WEST SUSSEX COUNTY COUNCIL CONSULTATION

TO:	Arun District Council FAO: Stuart Corbey
FROM:	WSCC - Highways Authority
DATE:	18 March 2019
LOCATION:	123 Longford Road Bognor Regis PO21 1AE
SUBJECT:	BR/329/18/PL Change of use of single dwellinghouse to 2 No. residential apartments
DATE OF SITE VISIT:	n/a
RECOMMENDATION:	Advice
S106 CONTRIBUTION TOTAL:	n/a

PROPOSED GROUND
FLOOR /
SITE LAYOUT

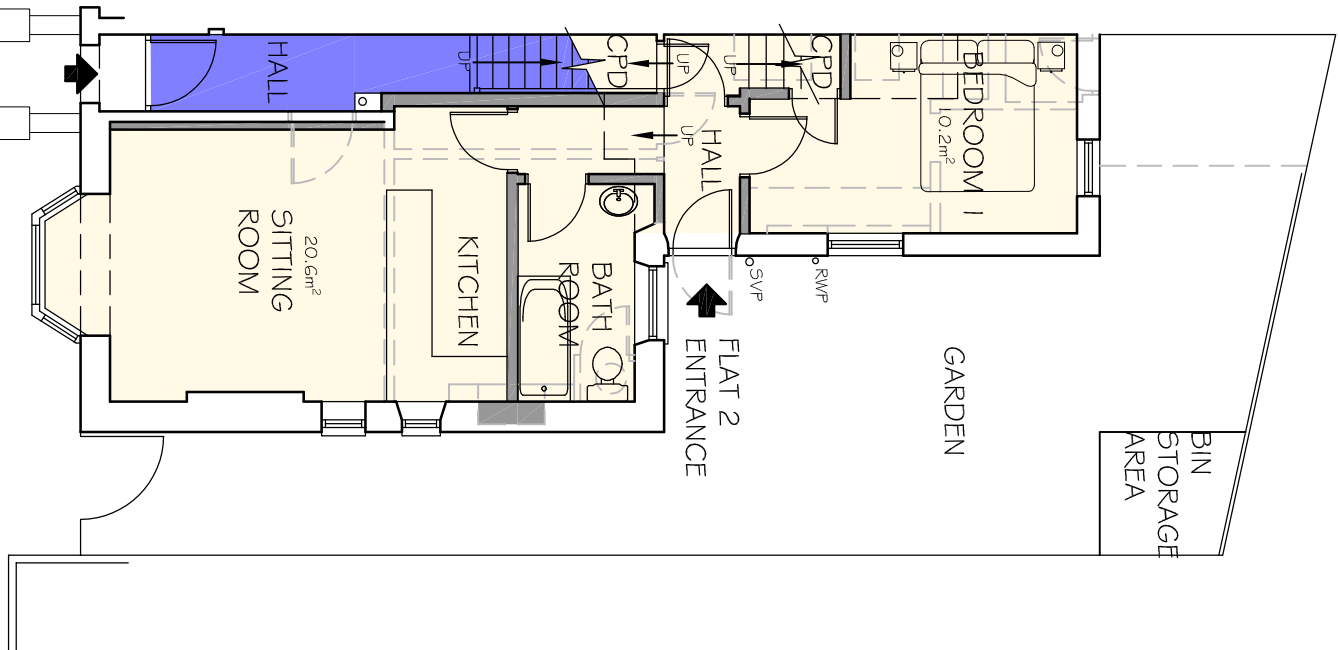
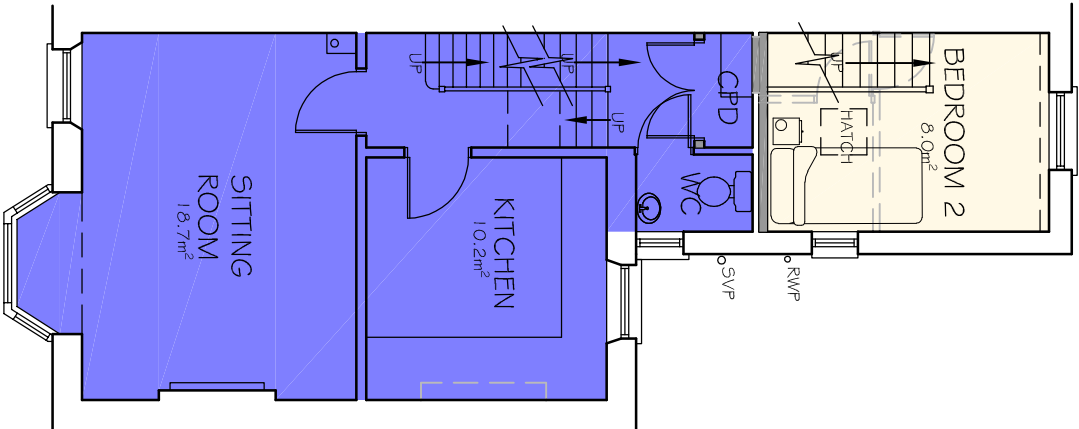
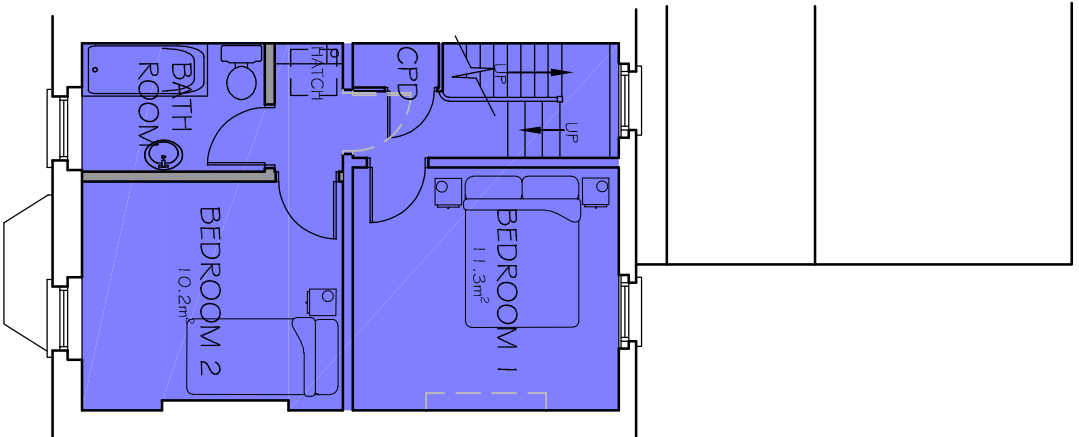
The existing 5 bedroom dwelling is not served with any off street car parking provision. The same will be the case for the proposed flats.
I have checked the parking demand using the WSCC Car Parking Demand Calculator.

It would be anticipated that the existing dwelling would create the demand for 2 car parking spaces. The proposed flats (2 x 2 beds) would also create the anticipated demand for a total of 2 spaces.

Both the existing and proposed dwellings would be reliant upon on street car parking provisions. In conclusion there would not be any anticipated increase in parking demand associated with this proposal.

If the Local Planning Authority are minded to grant planning consent a condition securing an independent or communal cycle parking provision would be advised.

No part of the development shall be first occupied until covered and secure cycle parking spaces have been provided in accordance with plans and details submitted to and approved by the Local Planning Authority.
